From: Amanda Scholes on behalf of Planning.Responses
Sent: 18 August 2020 09:49
To: Planning Scanning
Subject: FW: Windsong The Thatchway R/119/20/PL

From: Peter Wyles [REDACTED]
Sent: 05 August 2020 18:58
To: Anita Gardner <Anita.Gardner@arun.gov.uk>
Subject: Fwd: Windsong The Thatchway R/119/20/PL

I am contacting you in relation to the above planning application of Windsong. My neighbours and I (Lynwood, Eagles and us at Foxwood) put our objections in long before the final objection date back in March to Zac Denton in your planning office. All our objections were ignored and permission for these works were granted soon after the final date.

Existing Rear Elevation
Scale: 1:100

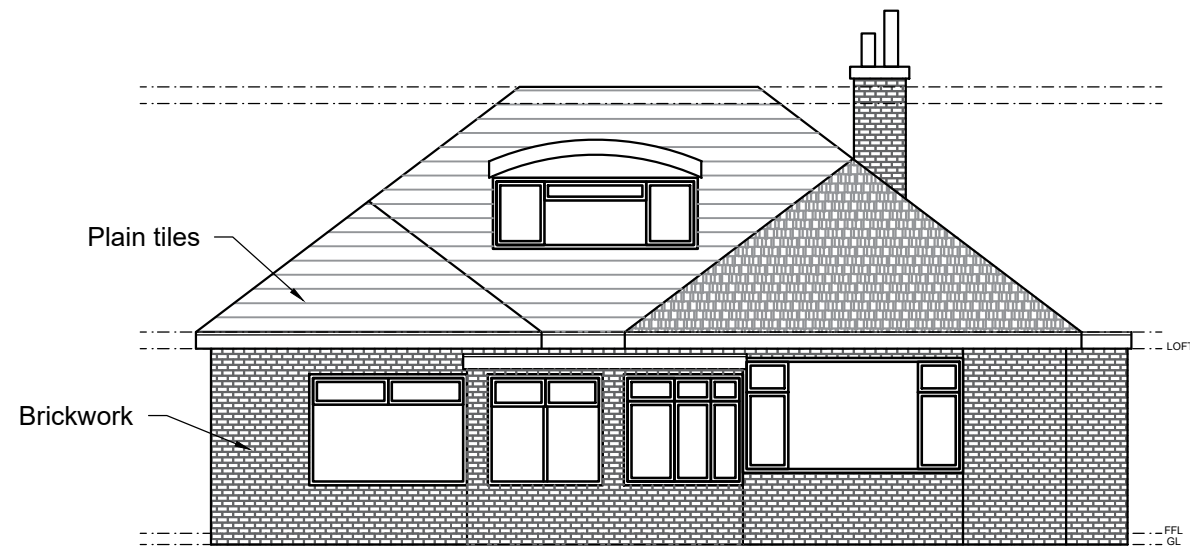
We are hoping that our objections would not be ignored a second time. Our main concern is the fact the three windows at the rear of these plans overlook our gardens, as we like to sit/sunbath in the summer this will completely remove our privacy which is an invasion to our lives. I do not think the planners thought of this but should be brought to their attention before these works begin. This situation is causing serious concerns to us and our neighbours in Lynwood next door.

If these works go ahead as planned we will have three windows at the rear looking into our gardens taking away our privacy, on top of this, we purchased Foxwood 20 years ago for the wonderful views of the sea which at the time was a huge USP. I wrote to Mr Hexton on behalf of our neighbours detailing our concerns and asked him if he would be kind enough to meet with us all and try to come to a different design of the roof. I received a arrogant reply saying "I go by the rule of law" and refused to meet with us. This is a very friendly area where we all get along brilliantly, and if any of us have works planned we consult each other to be sure of not causing any problems, so this does not appear to be someone who wants to "fit in" with his neighbours, quite the reverse it seems.
